CAWSTON PARISH COUNCIL Norfolk Boreas Offshore Windfarm Inquiry Deadline 15 Submission

CAWSTON PC – REPORT OF MEETING WITH ORSTED (HORNSEA THREE) 27TH AUGUST 2020

CAWSTON HIGH STREET - INTERVENTION SCHEME  
Scale 1:500

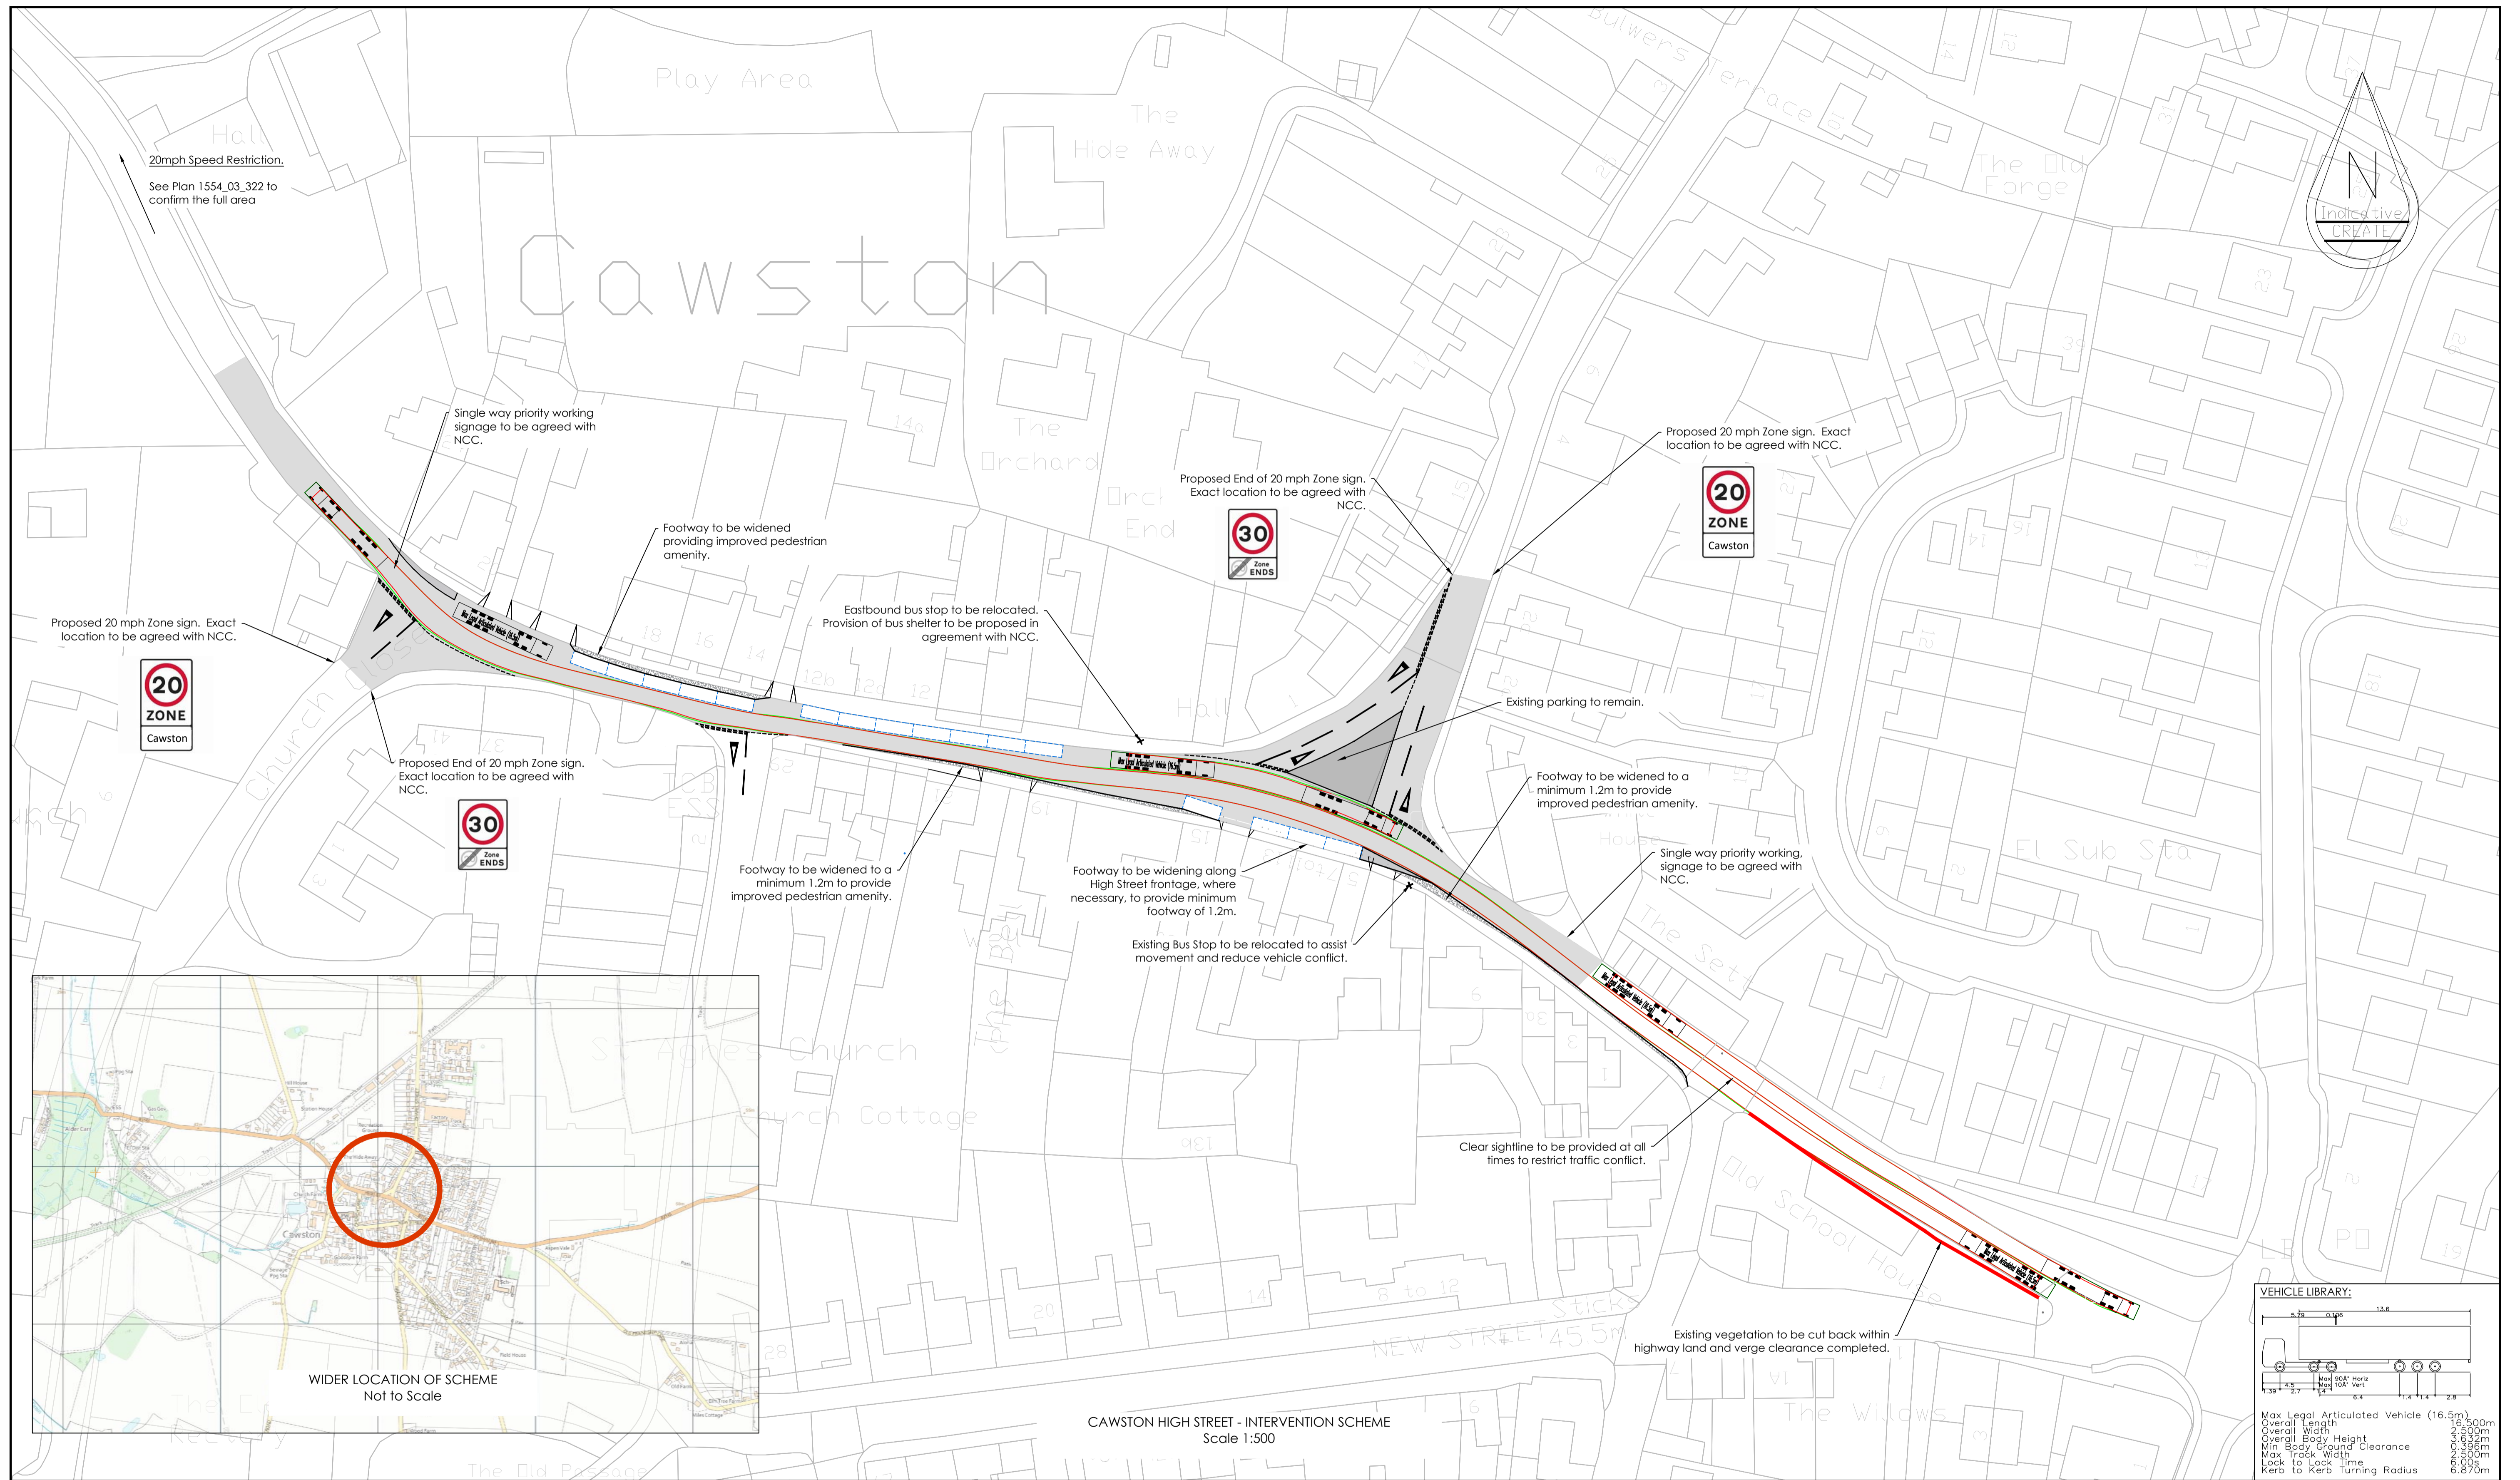
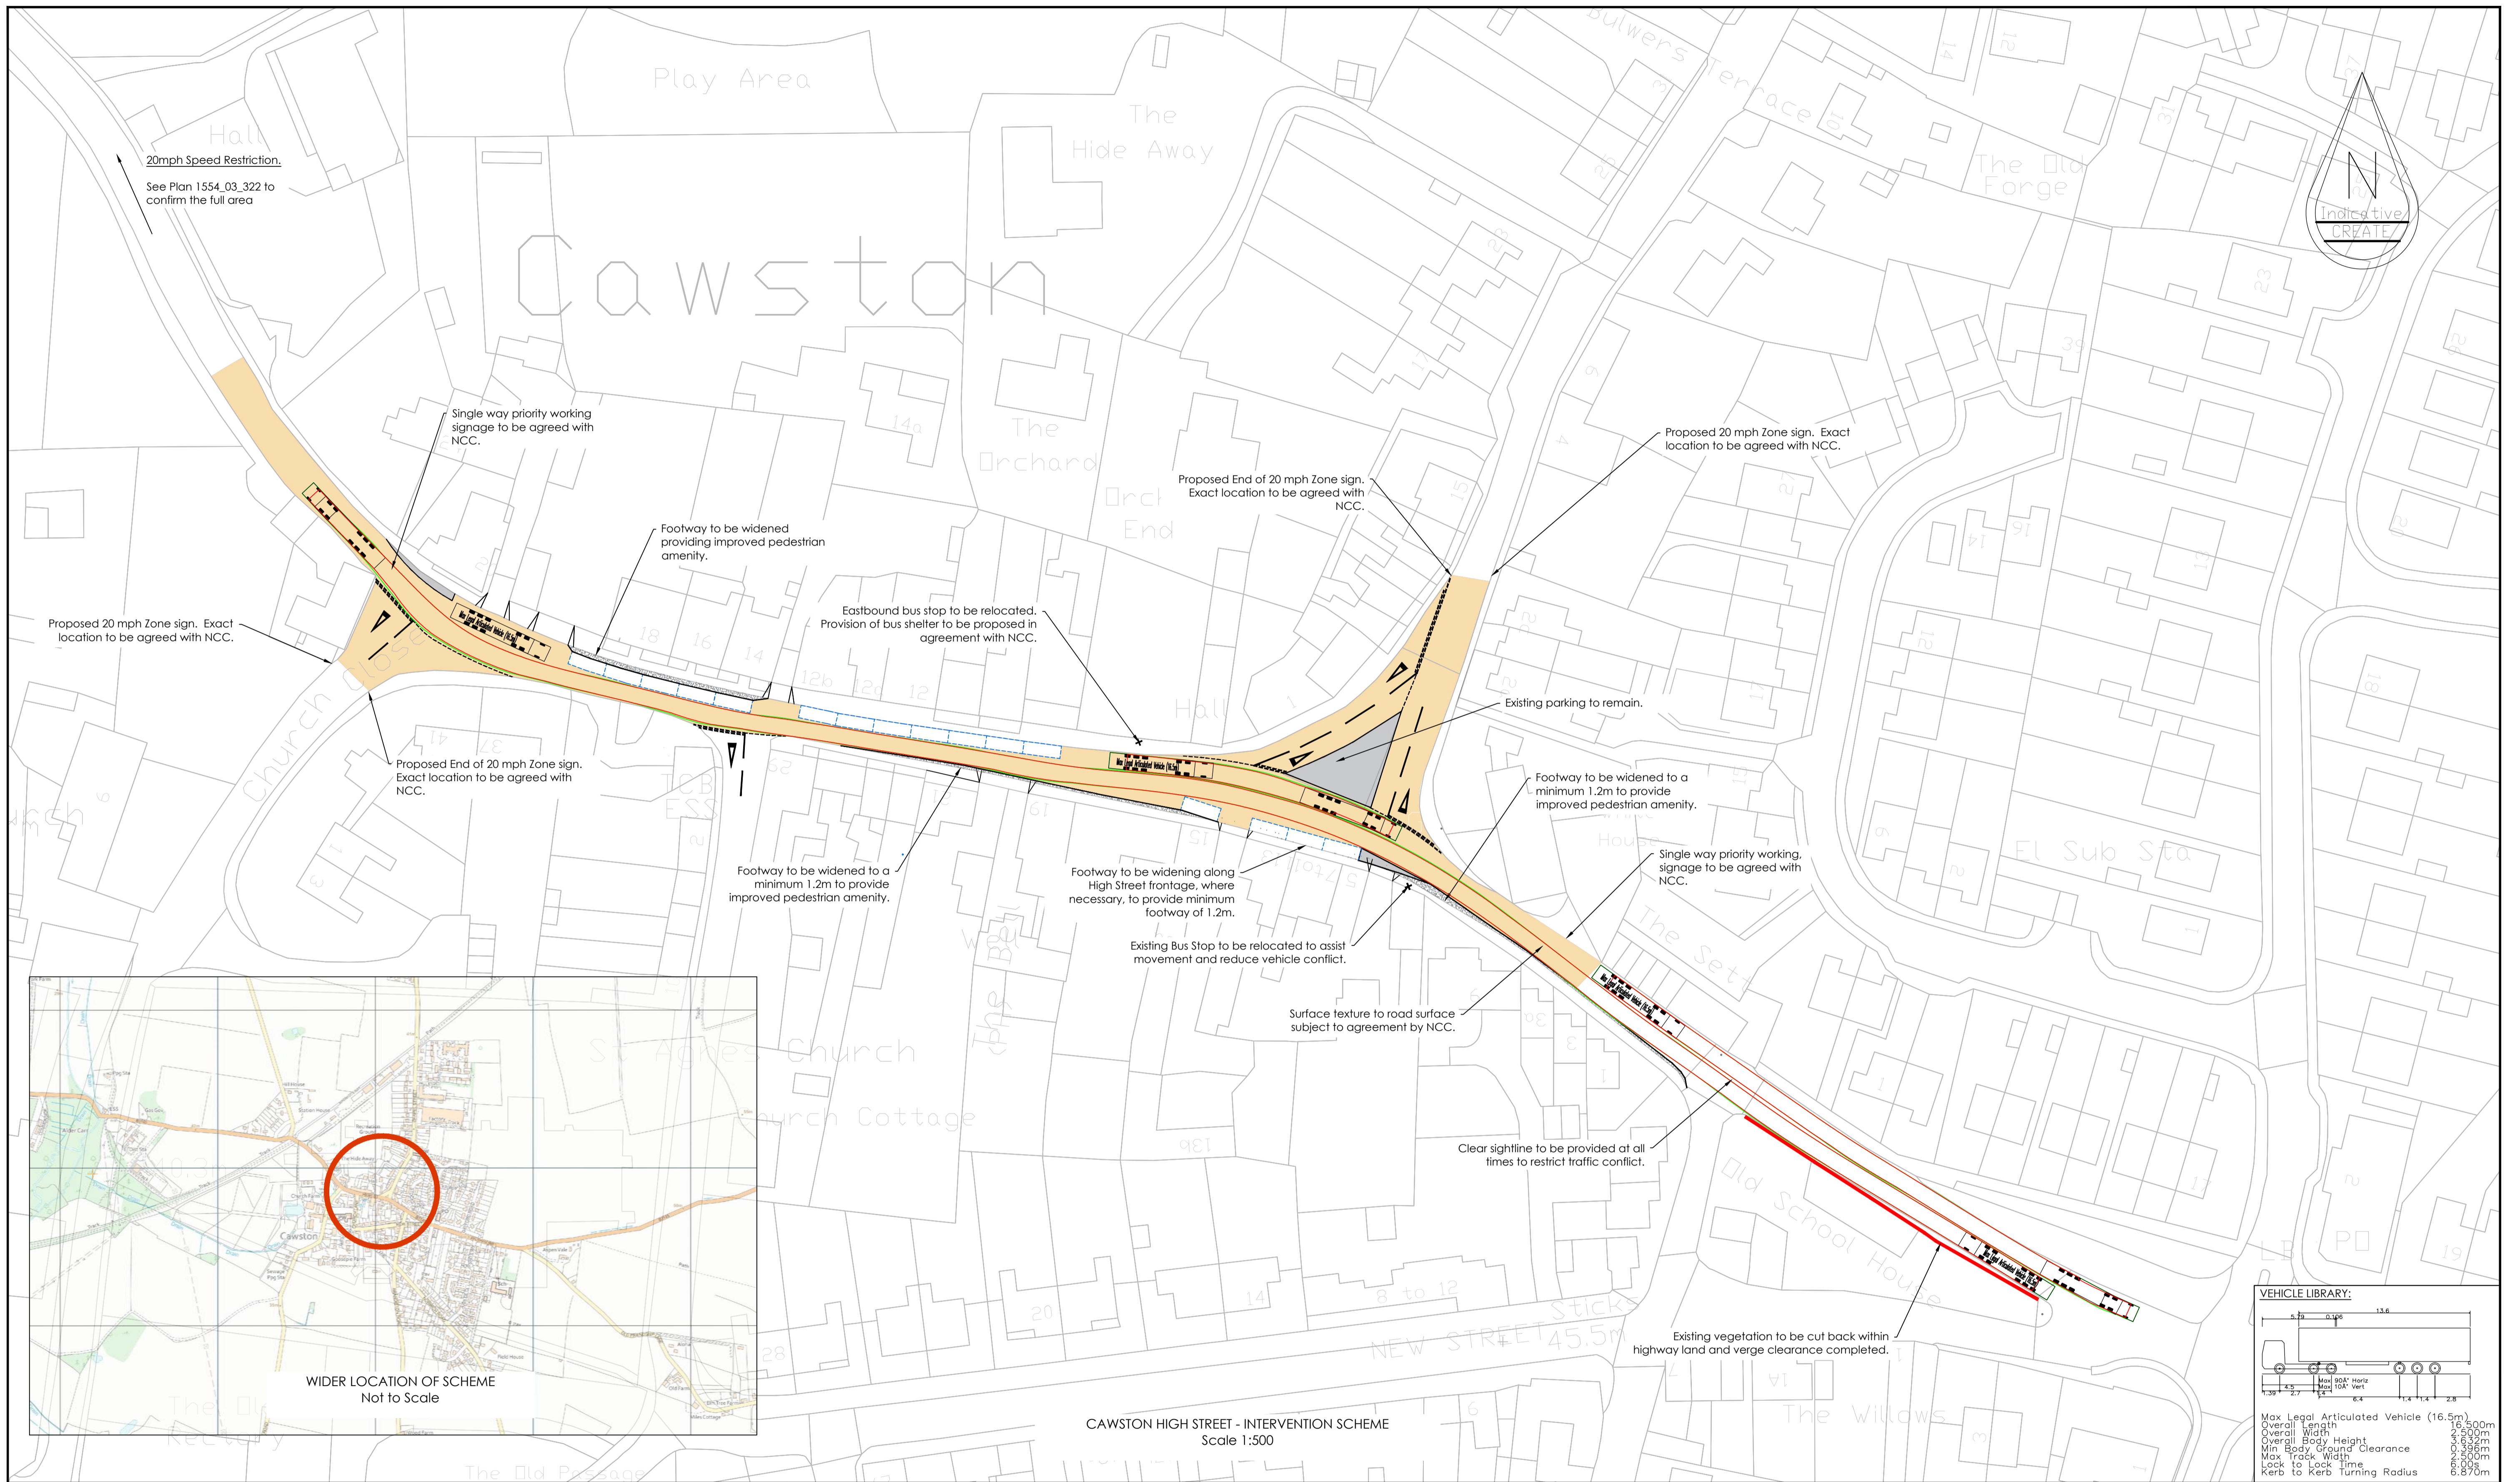
Hornsea 3's Abnormal loads call into question further the possibility that HGVs might pass safely in Cawston village centre. The swept path data upon which the applicant has relied to claim technical feasibility for their scheme is based on even less accurate vehicle dimensions.

Congestion from convoys, which are effectively temporary road closures, makes platooning of traffic approaching Cawston inevitable. Platooning of traffic, makes the applicant's HIS passing place concept impractical and ineffective. Access for emergency vehicles, public transport and existing traffic flows will be disrupted with unacceptable increases in waiting times.

Temporarily to close the footway in the centre of Cawston to allow an abnormal load to overlap the narrow footway on the south side of the High Street.

- Closing the narrow footway is impractical and threatens Grade 2 listed buildings on the High Street.
- These are photographs were taken after a recent accident on the same footway which Hornsea 3 propose to use for their abnormal loads

- The proposal to close the footpath endangers residents' properties, the timely passage of emergency vehicles, and endangers parked vehicles on the north side of the High Street.

Introducing parking restrictions to clear parked cars from the north side of Cawston High Street.

- It is not feasible to apply a temporary restriction which only operates at convoy times.
- Economic and social impacts on local businesses and residents
- Removing protection of pedestrians from passing HGV traffic and encouraging excess speed for vehicles in the applicant's, largely unmarked, "20mph zone."
- The following is an extract from the Applicant's Road Safety Audit, Document Reference : ExA.AS-3.D5.V1 Deadline 5

It is planned to achieve this by closing the High Street southern footpath during transit and retaining on street parking. There would be a 0.5 metre overhang of the footpath.

The two suggestions were to close the footpath on the southern side of the High St for the duration of transit, allowing a 0.5 metre overhang, or to take away the on street parking in this area.

The value of on street parking has been discussed many times in the various Examinations; all parties have agreed upon its importance. In fact it is a cornerstone of the HIS proposed by Vattenfall and their rationale for creating a 20mph "zone". Removing parking is out of the question.

The proposal to close the footpath is equally unacceptable. We would question whether there is enough combined road and pavement width for this to be done safely. The one recent experience of such an abnormal load damaged property and caused considerable traffic problems.
